East Anglia One North (EA1N) and East Anglia Two (EA2) Offshore Wind Farms

Planning Inspectorate Reference: EA1N – EN010077, EA2 – EN010078

Deadline 6 – 24 February 2021

East Suffolk Council's Response to Examining Authority's Second Round of Written Questions

Figure: 29.37e
Viewpoint 5: Public Right of Way, near Moor Farm

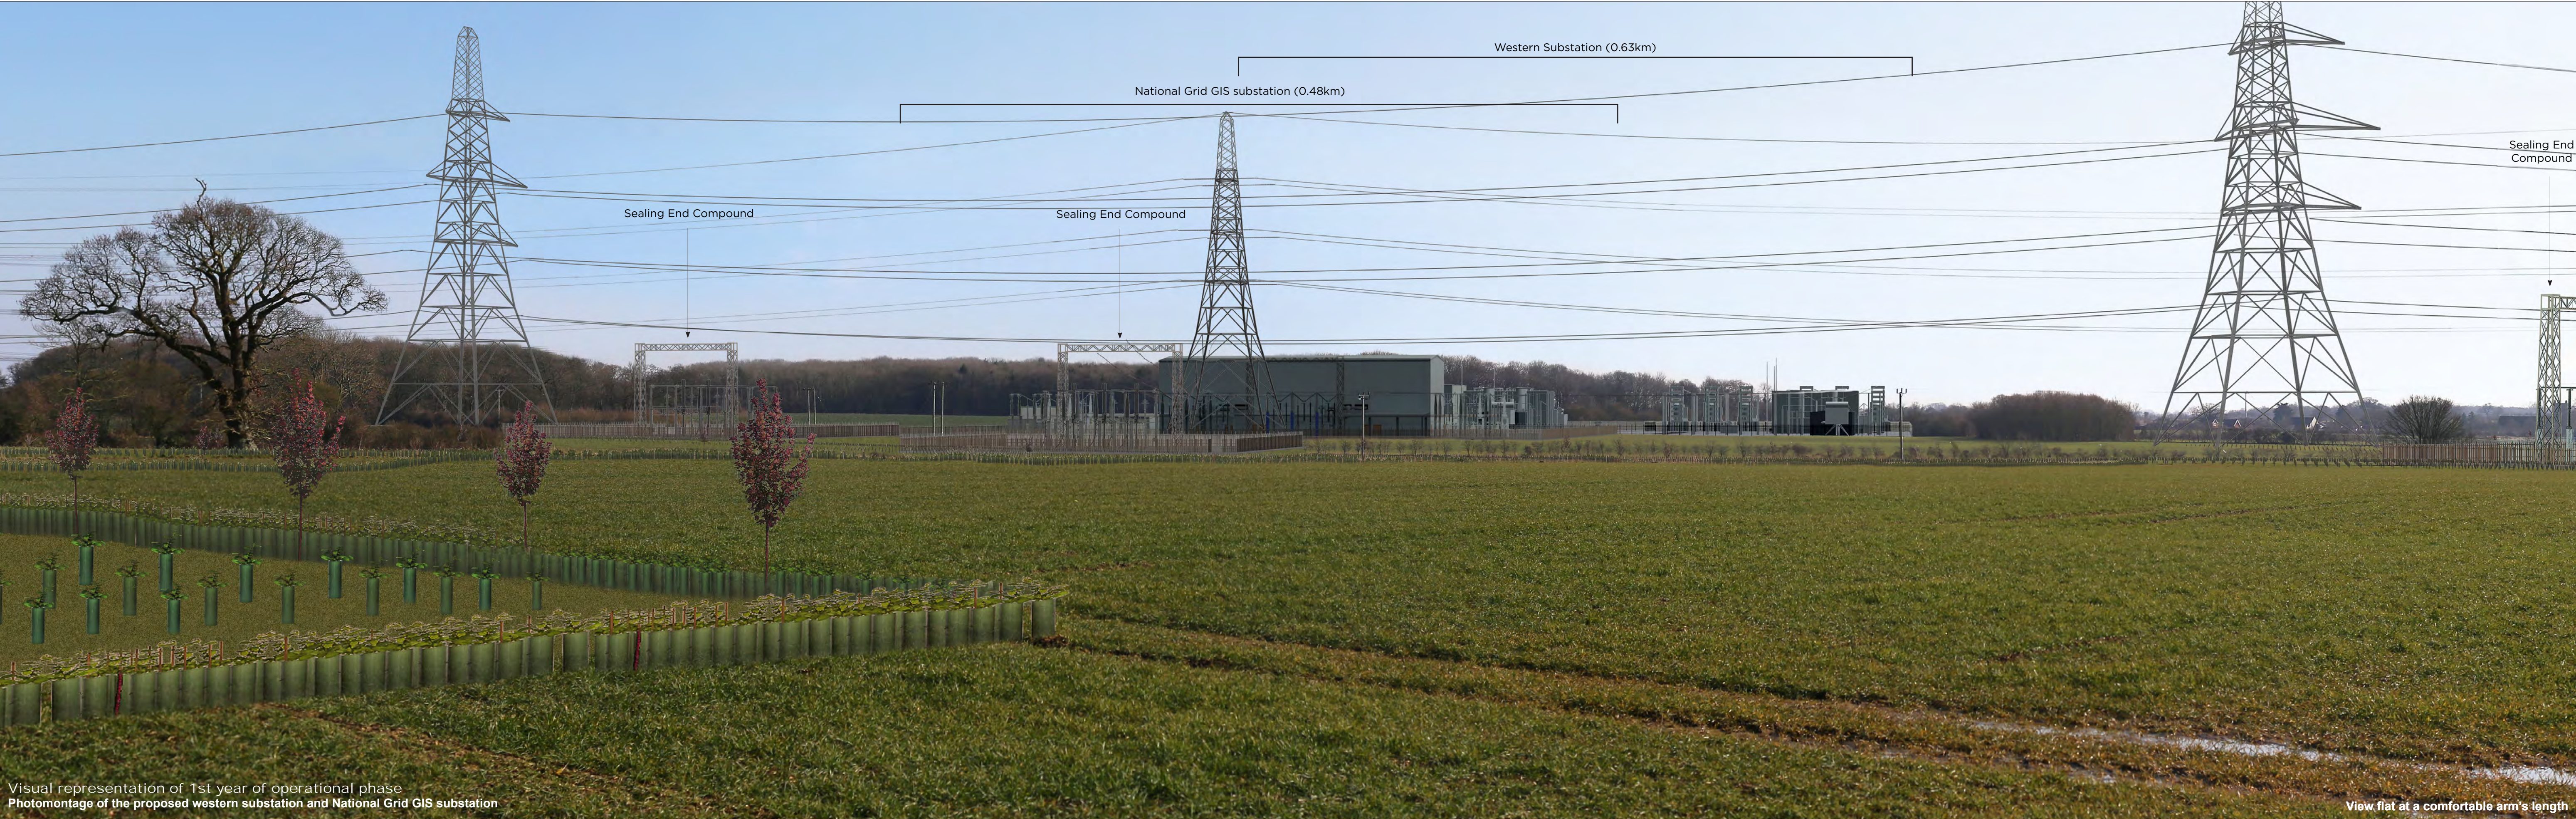
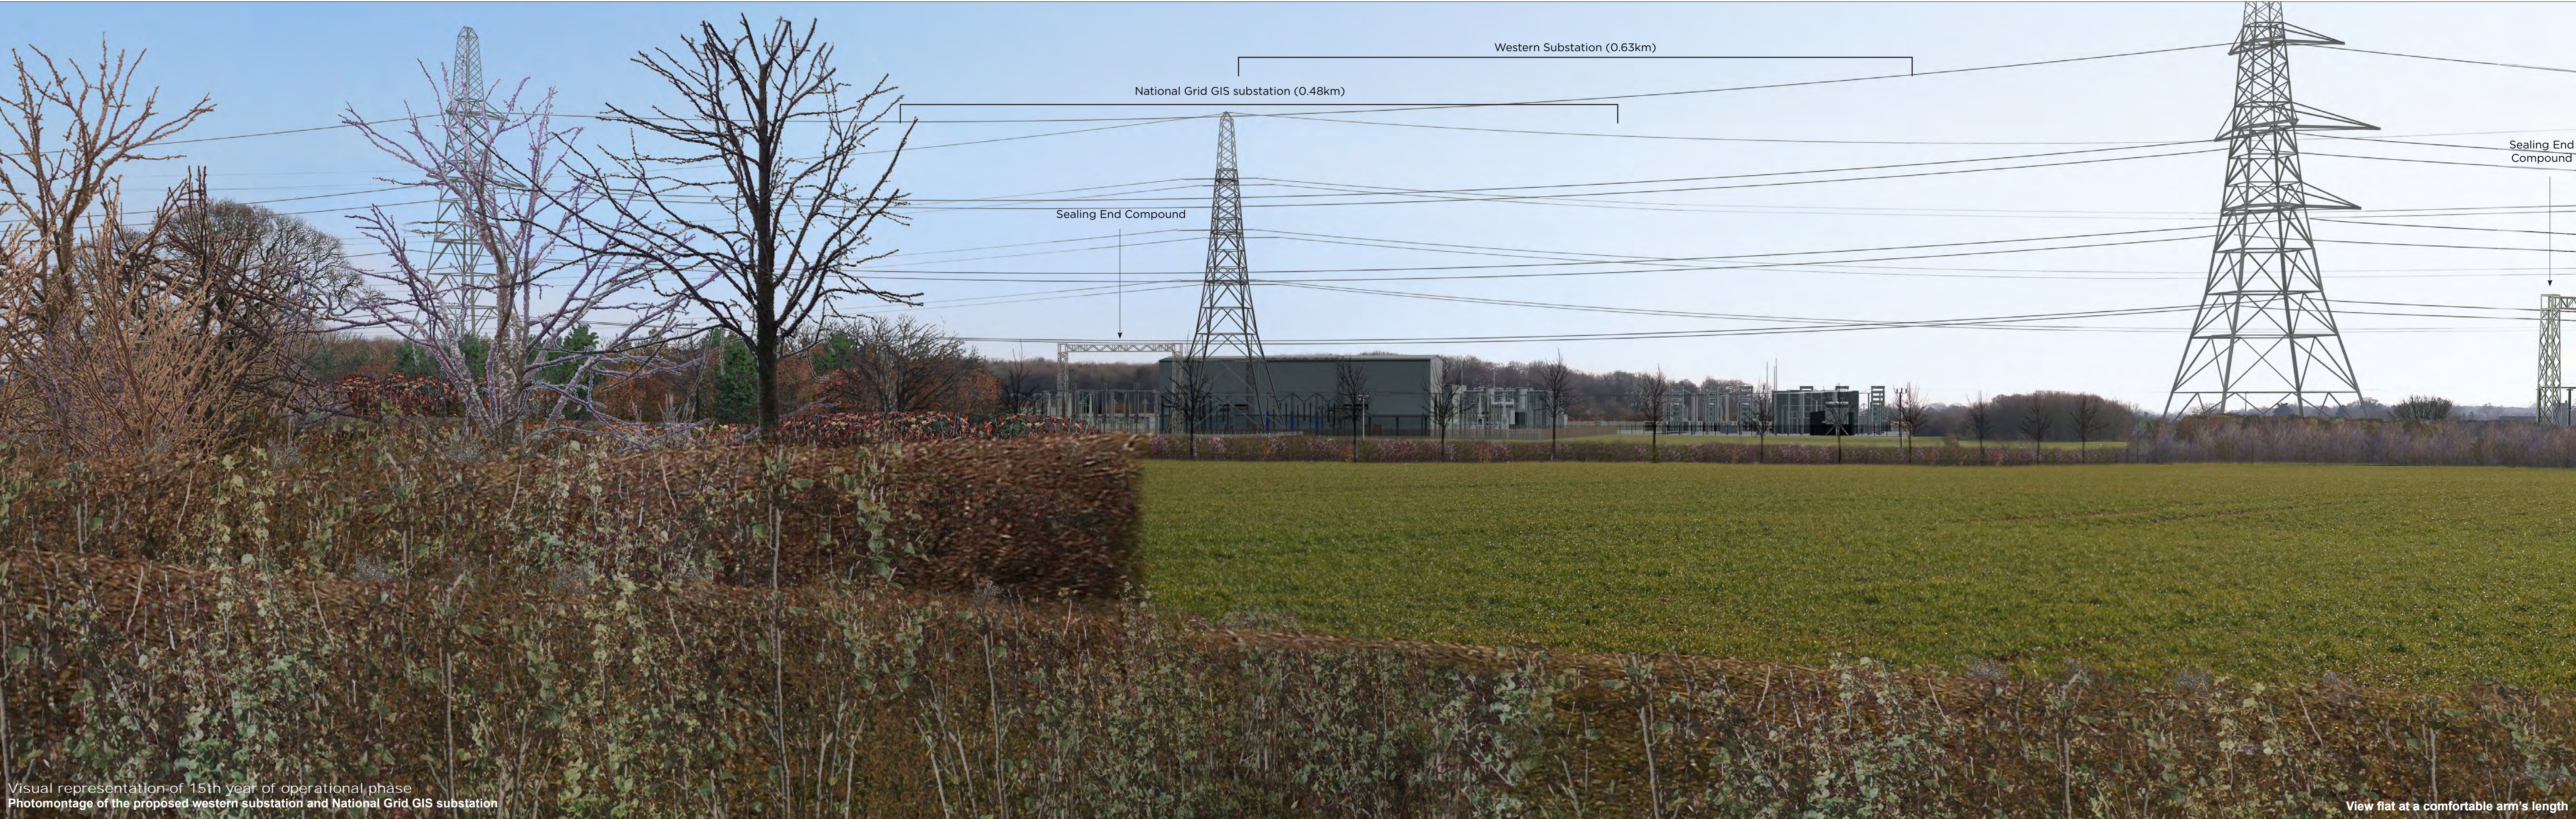
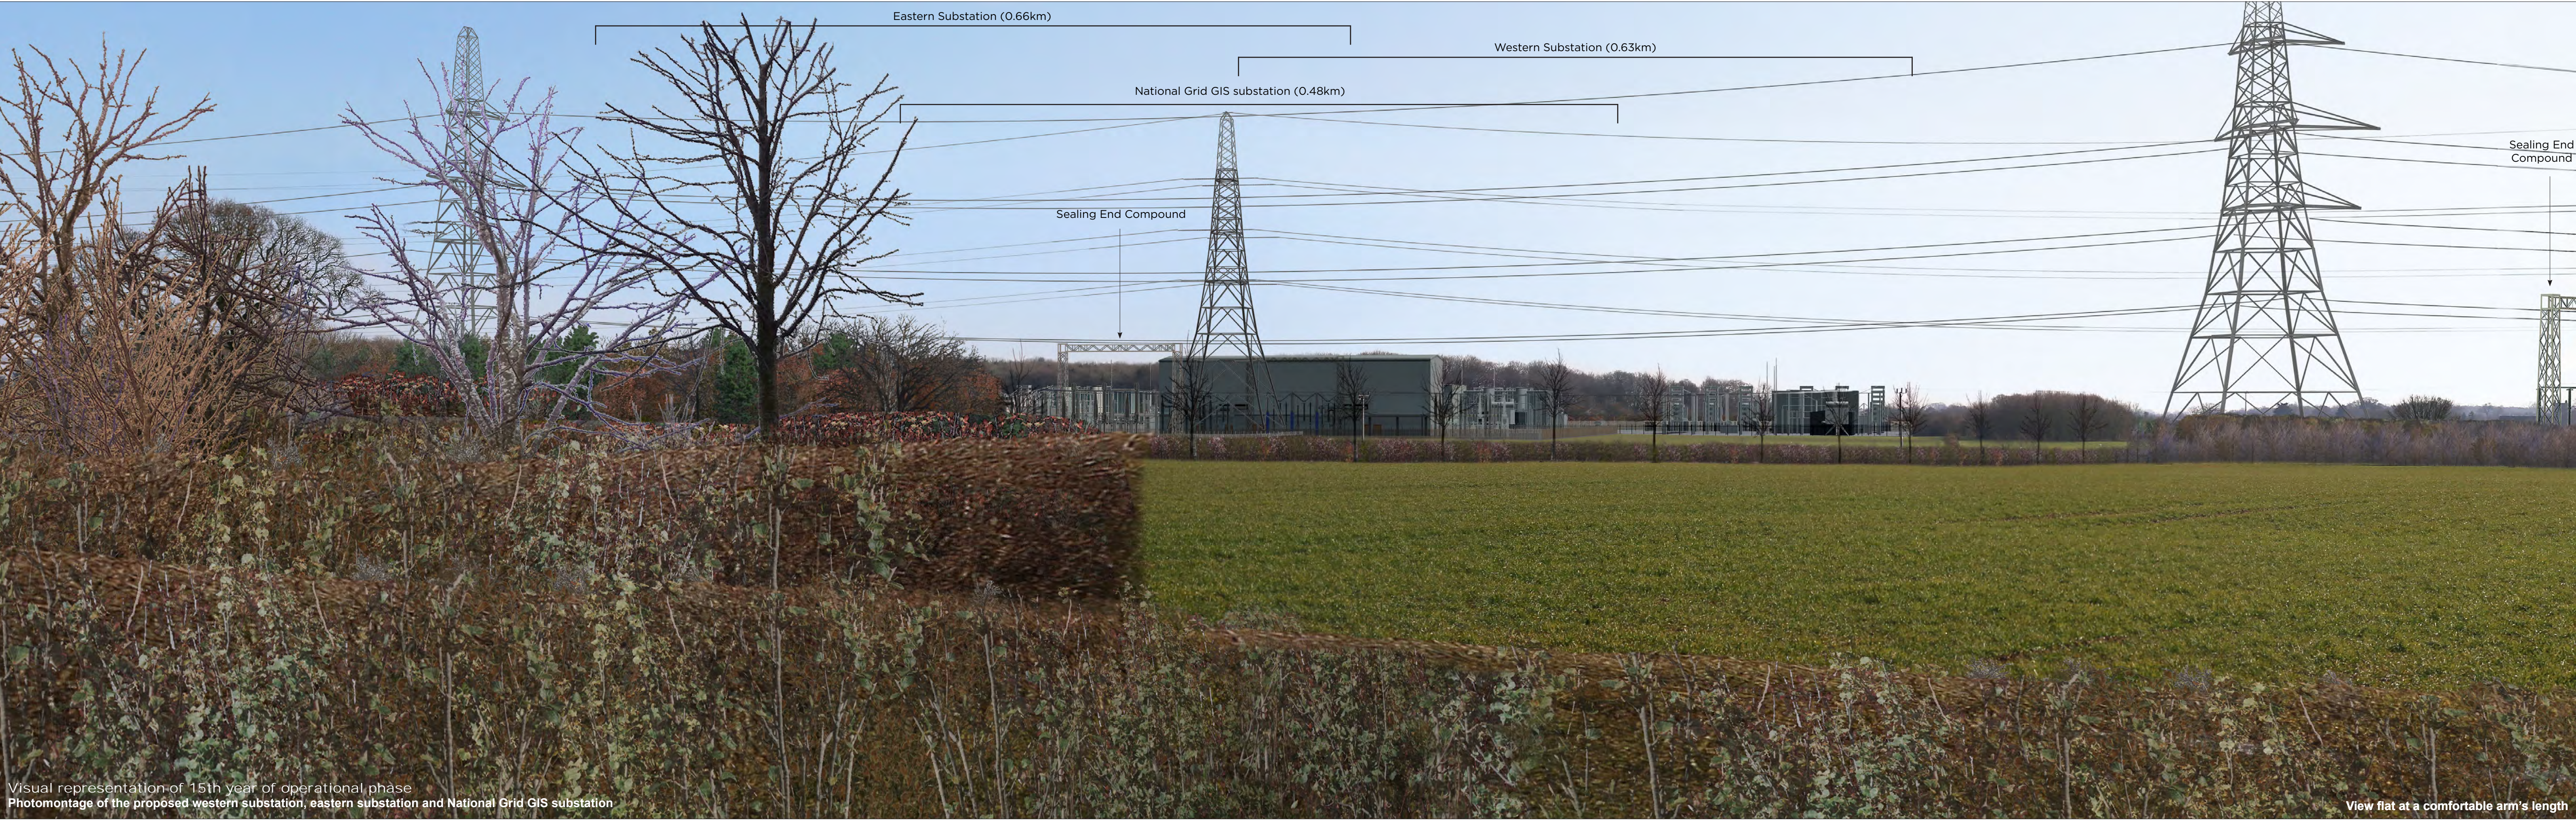
2.10.7	Applicants, IPs	Proposed sealing-end compounds. [REP4-036] EA1N Landscape and Visual Impact Assessment Addendum		<p>From the latest supplied photomontages in respect of Viewpoint 5, it would appear that the western most sealing end compound will remain visually prominent in the landscape even 15 years post planting. The latest landscape planting plan indicates that this planting is proposed as edge woodland mix. We suggest that</p>

<p>- Appendix 5 - Viewpoint 5 PRoW near Moor Farm (Figure 29.17 Update) shows at year 15 that the western most sealing end compound, in particular, is clearly visible from the viewpoint despite the additional planting described in paragraphs 45, 100 and 110 of the OLEMS [REP3- 030] to provide additional screening.</p> <p>Is the additional planting successful in providing additional screening and, if not, are there further measures that can be taken to more adequately screen the sealing end compounds?</p>		<p>consideration should be given by the Applicants to changing the planting mix to include taller growing species, unless there are technical restrictions that prevent this being an option.</p>
